**Project Name: \*** B-5639 Duplin County

**B-5639**, Replace Bridge 36 on NC 11 over Maxwell Creek, Duplin County

**From:** [Cashin, Gordon E](#)  
**To:** [Shaver, Brad E CIV USARMY CESAW \(USA\)](#)  
**Cc:** [Steenhuis, Joanne](#); [Herndon, T. Mason](#); [Matthews, Monte K CIV USARMY CESAW \(USA\)](#); [Rivenbark, Chris](#)  
**Subject:** RE: [External] B 5639 NW 23 request  
**Date:** Friday, April 17, 2020 2:17:17 PM  
**Attachments:** [B-5639 Reforestation detail.pdf](#)  
[B-5639 DMS Acceptance.pdf](#)  
[B-5639 Permit Package Wetland 20200415.pdf](#)  
[B5639 Wetland Impact Summary Form 20200415.xlsx](#)

**From:** Shaver, Brad E CIV USARMY CESAW (USA) <Brad.E.Shaver@usace.army.mil>  
**Sent:** Thursday, April 9, 2020 3:03 PM  
**To:** Rivenbark, Chris <crivenbark@ncdot.gov>; Cashin, Gordon E <gcashin@ncdot.gov>  
**Cc:** Steenhuis, Joanne <joanne.steenhuis@ncdenr.gov>; Herndon, T. Mason <tmherndon@ncdot.gov>; Matthews, Monte K CIV USARMY CESAW (USA) <Monte.K.Matthews@usace.army.mil>  
**Subject:** [External] B 5639 NW 23 request

PERMIT DRAWING  
SHEET 4 OF 15

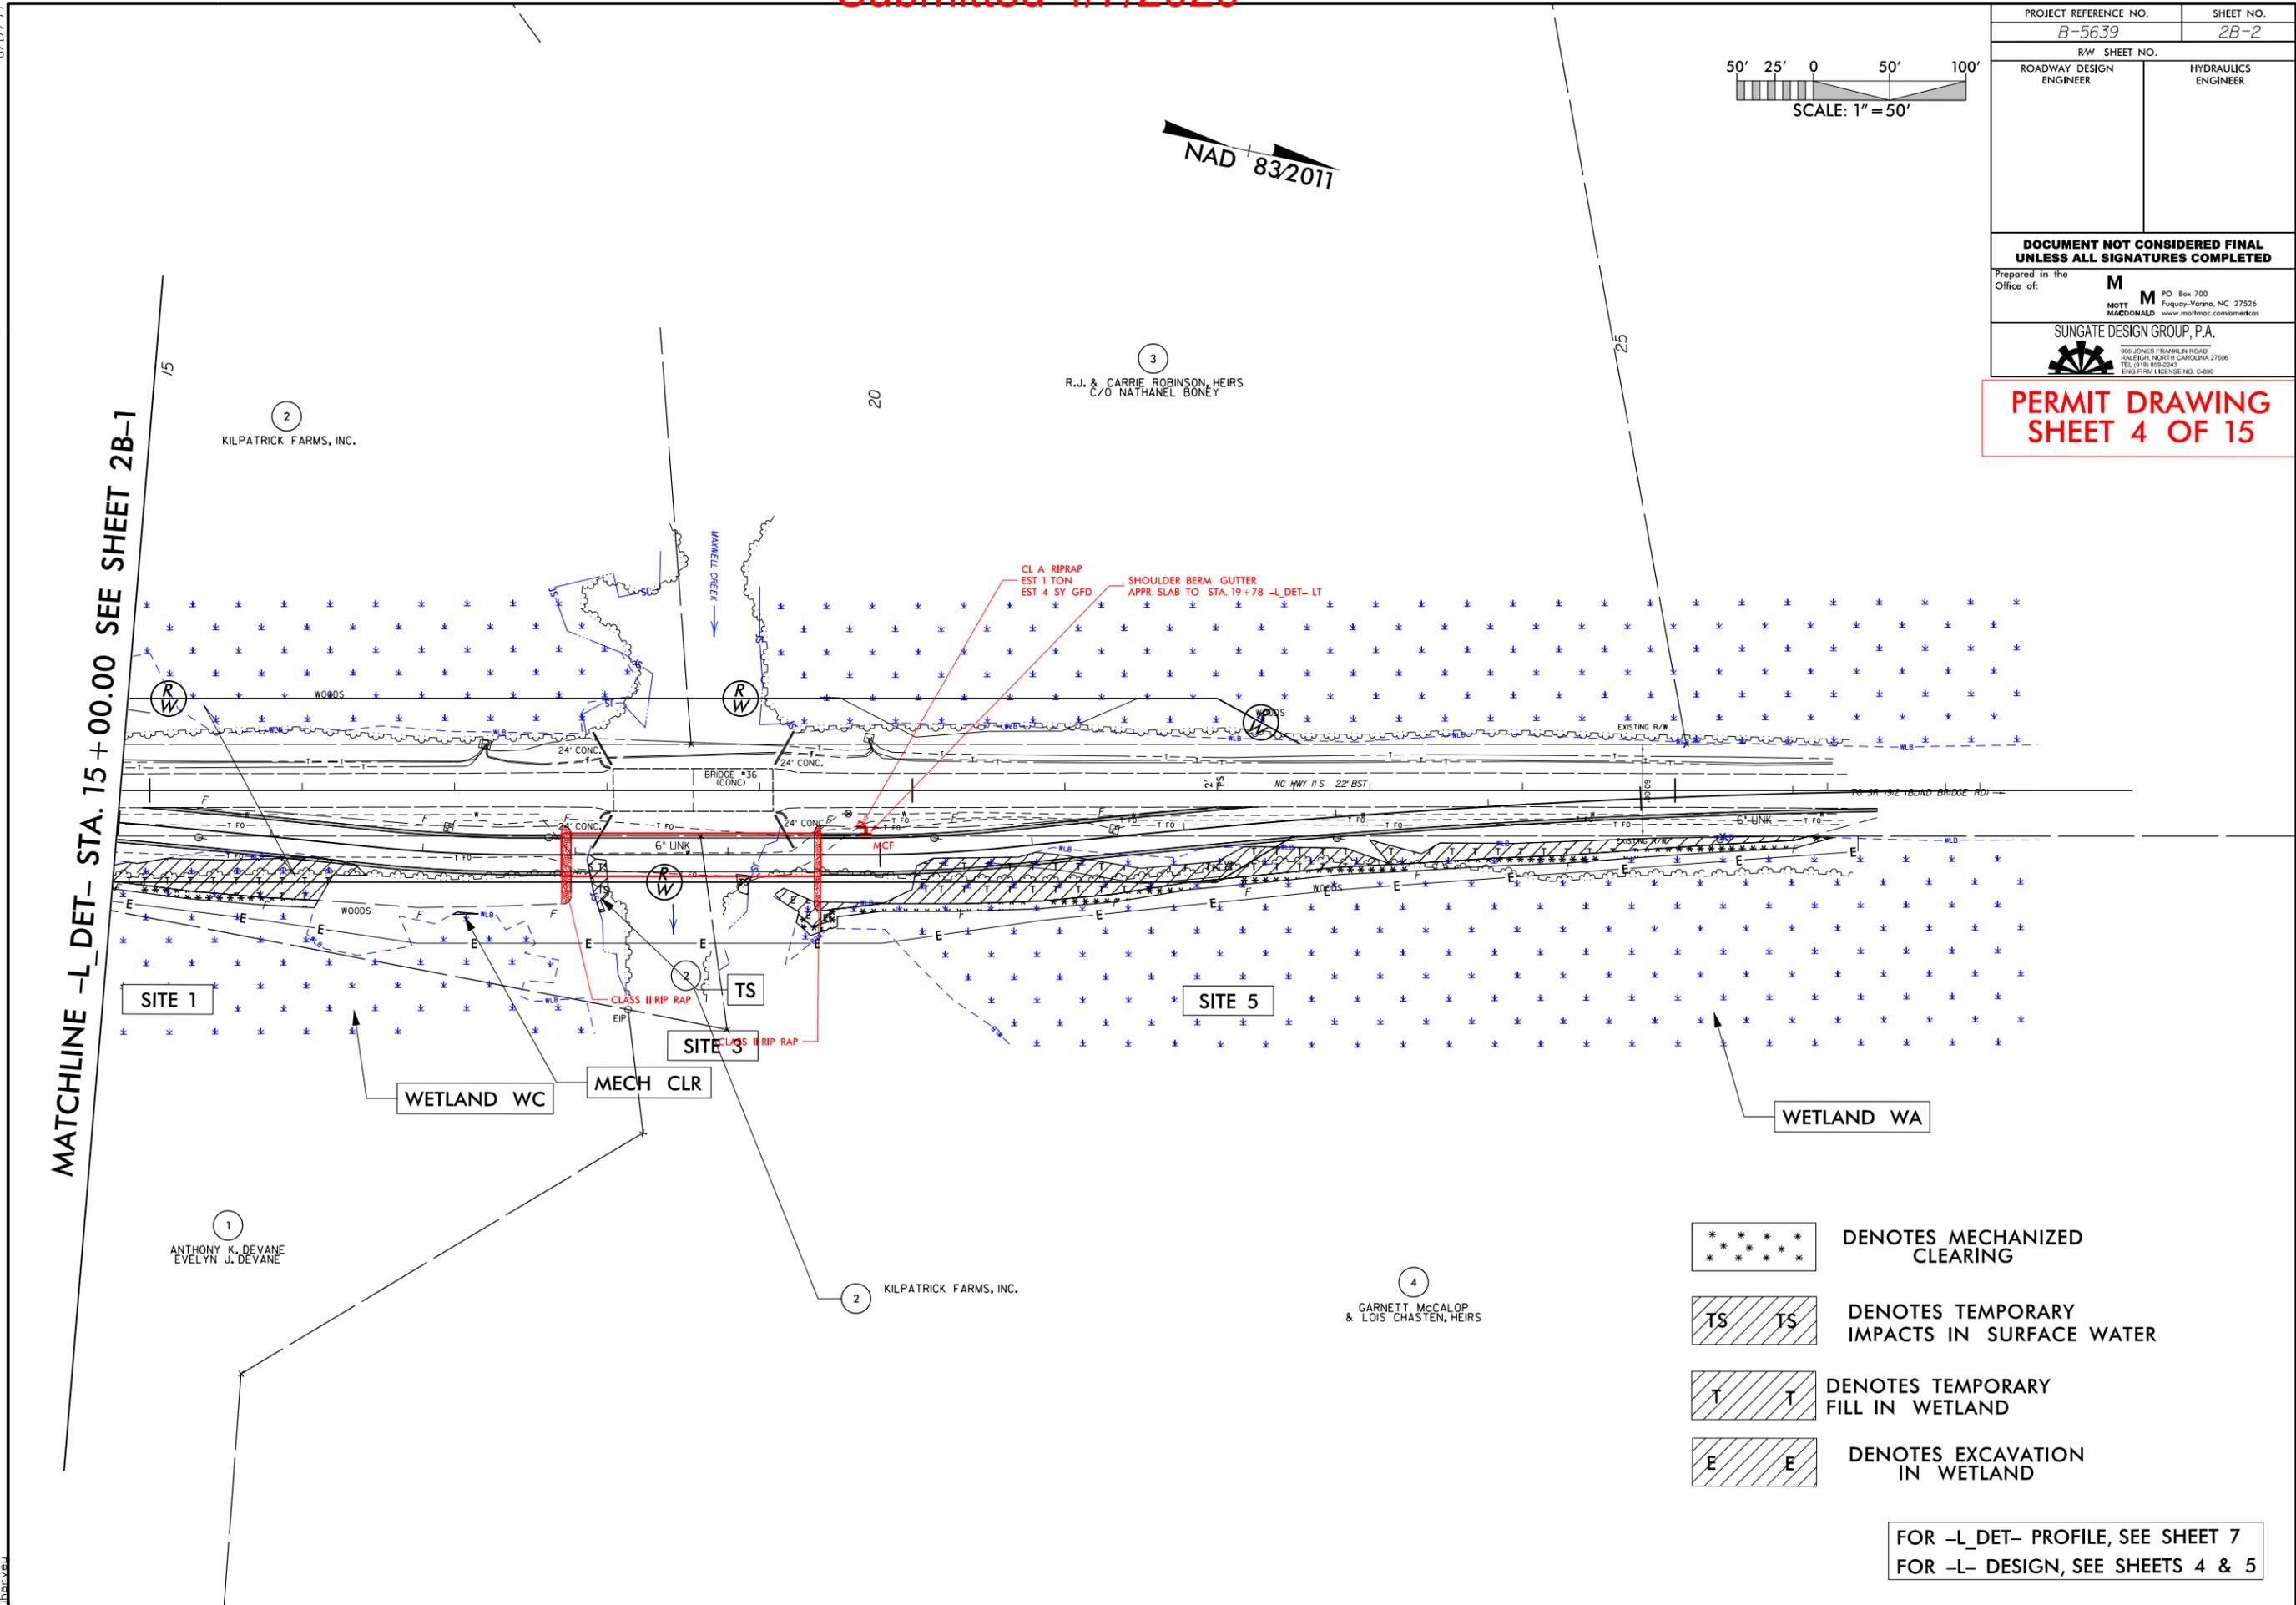
- Please include the mitigation reservation letter from NC DMS.
- The current plan calls for permanent impacts (MC) bordering the temporary impacts. Typically temporary impacts are bordered by temporary impacts (HC). Please either change this or explain why additional avoidance can't be realized.

3. The drawings have been changed to put handclearing outside of the detour instead of mechanized.
4. Sheet 5 is in the new package. (attached)
5. Division 2 has indicated that the slope of the temporary detour will be wrapped with geotextile fabric to aid in restoring the area back to preexisting elevations. A reforestation detail sheet has been prepared by our mitigation and monitoring group (attached), and the site can be monitored for 2 years if desired.

PERMIT DRAWING  
SHEET 10 OF 15

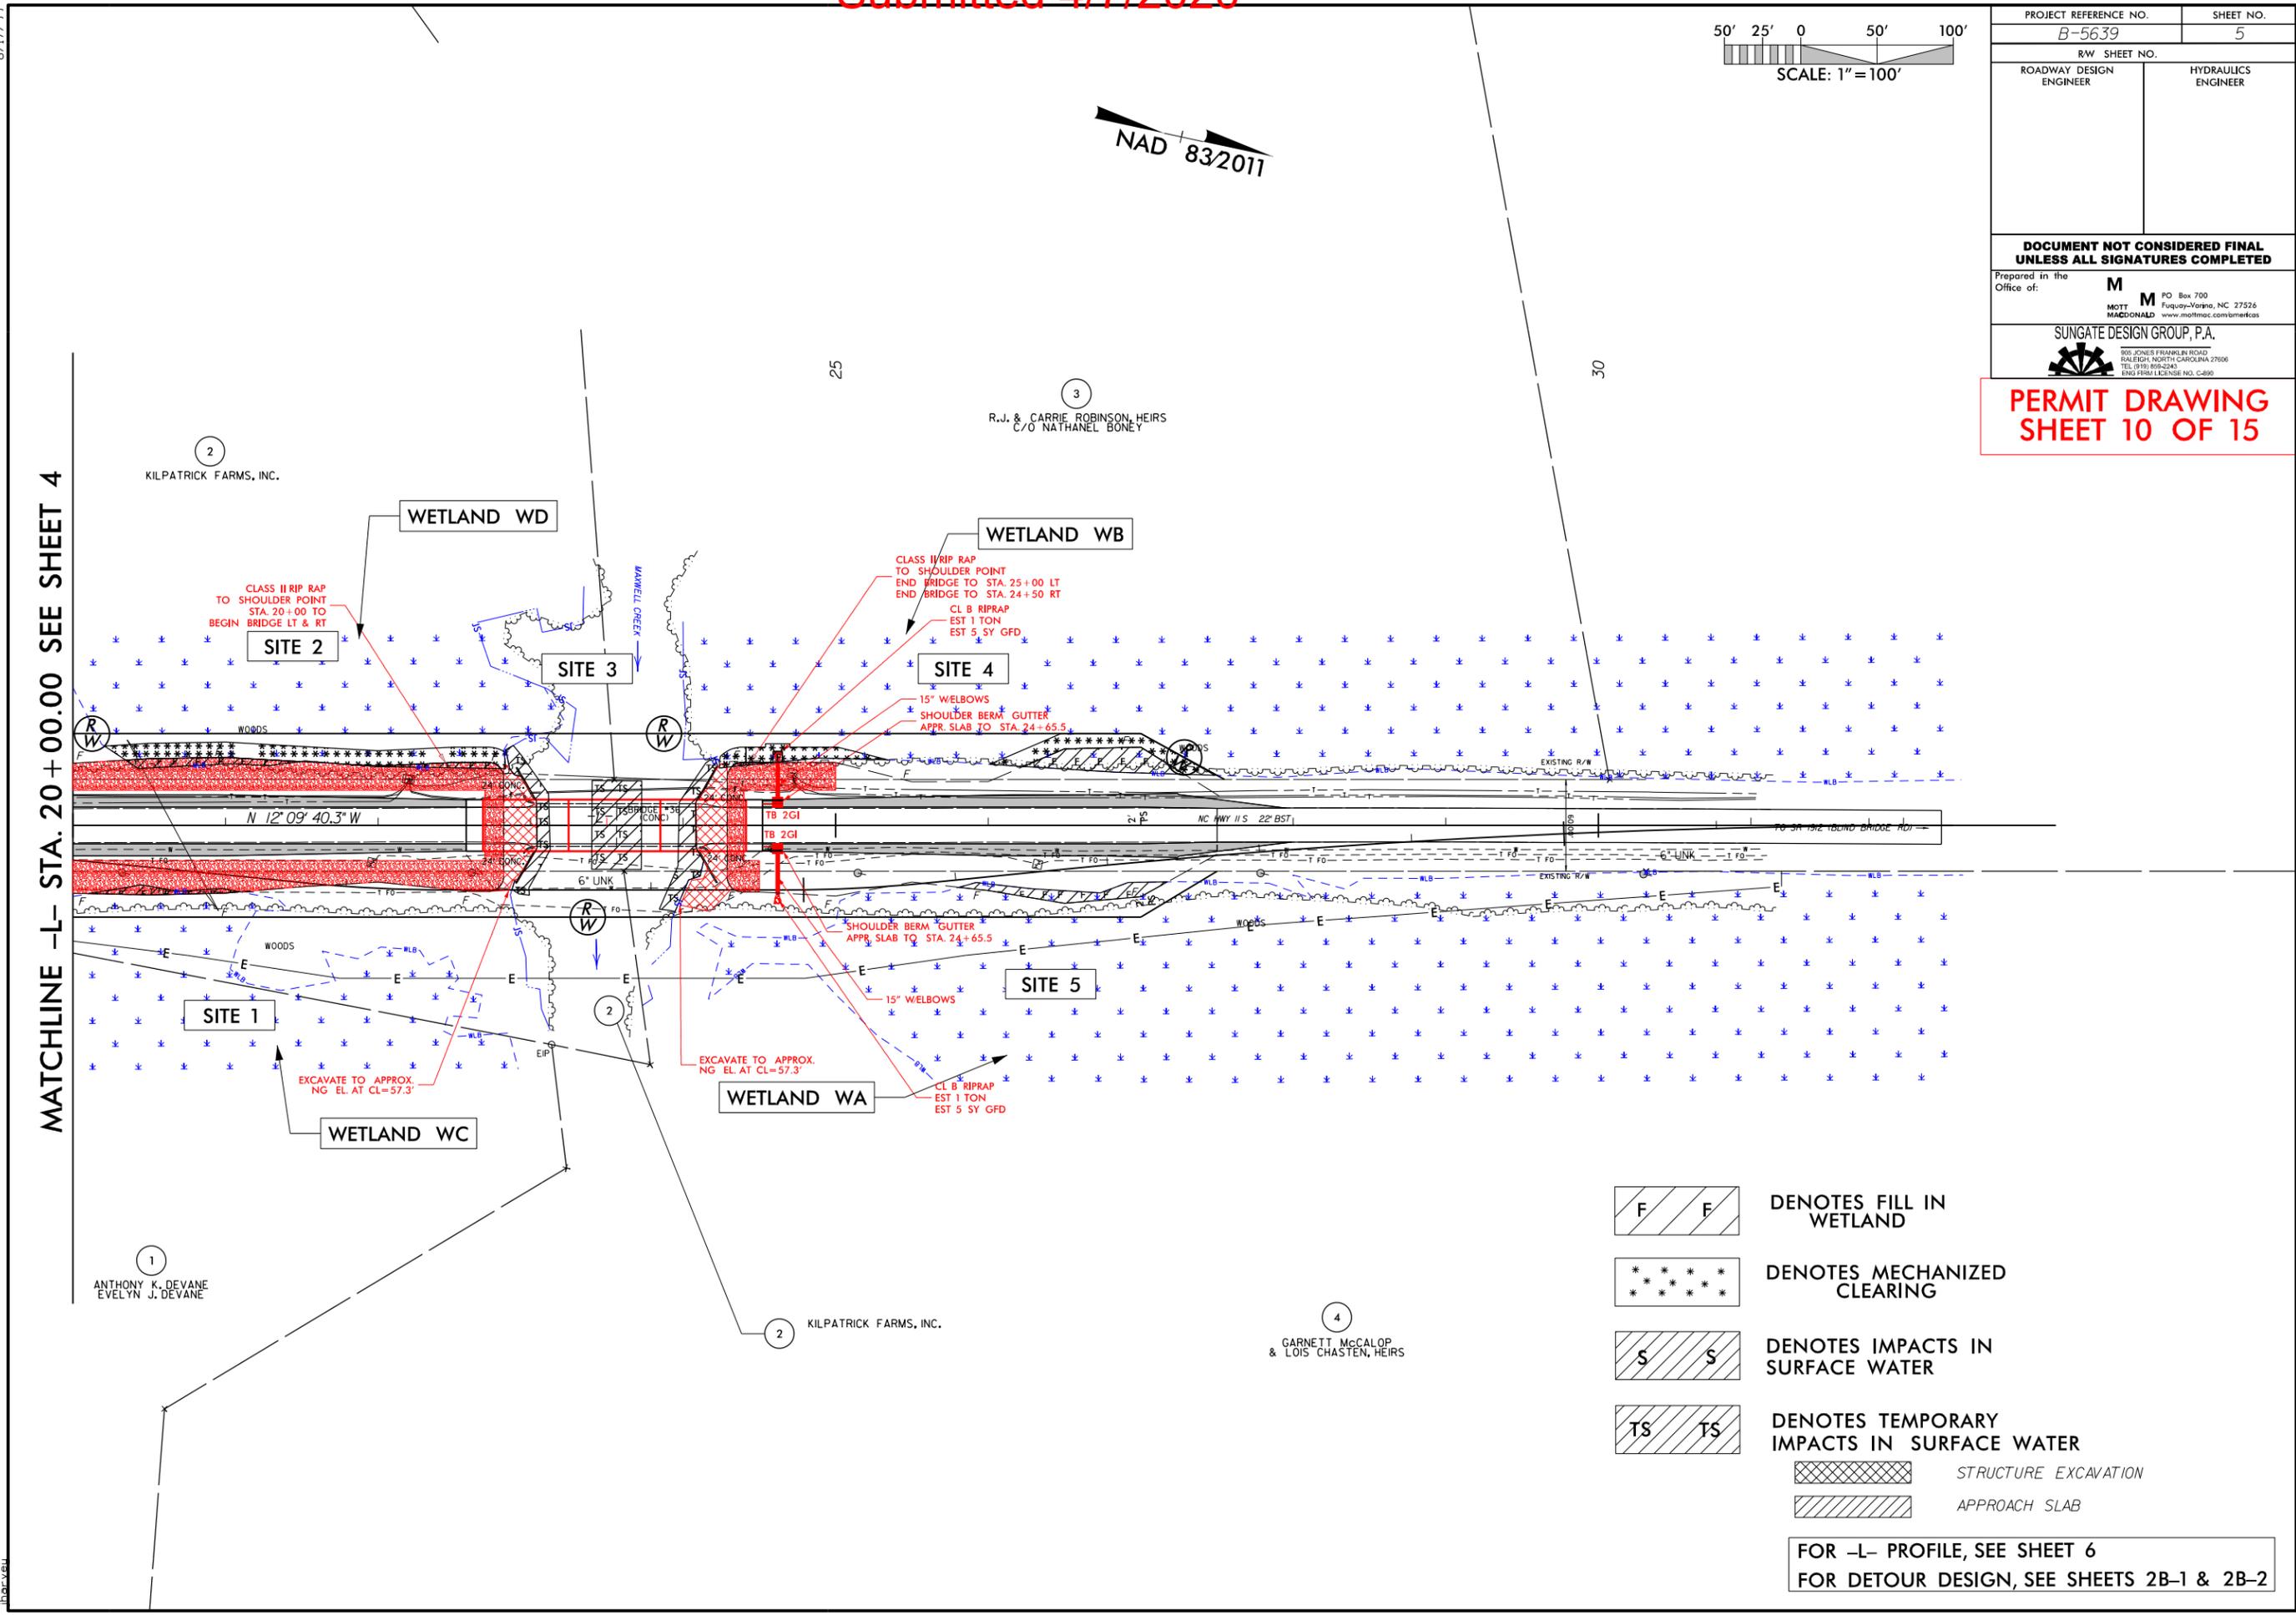
- Permit drawing 10 of 15 has a match line on the left side of the page to sheet 5. Sheet 5 is not in the package please provide this sheet so that impacts can be confirmed absent or present.
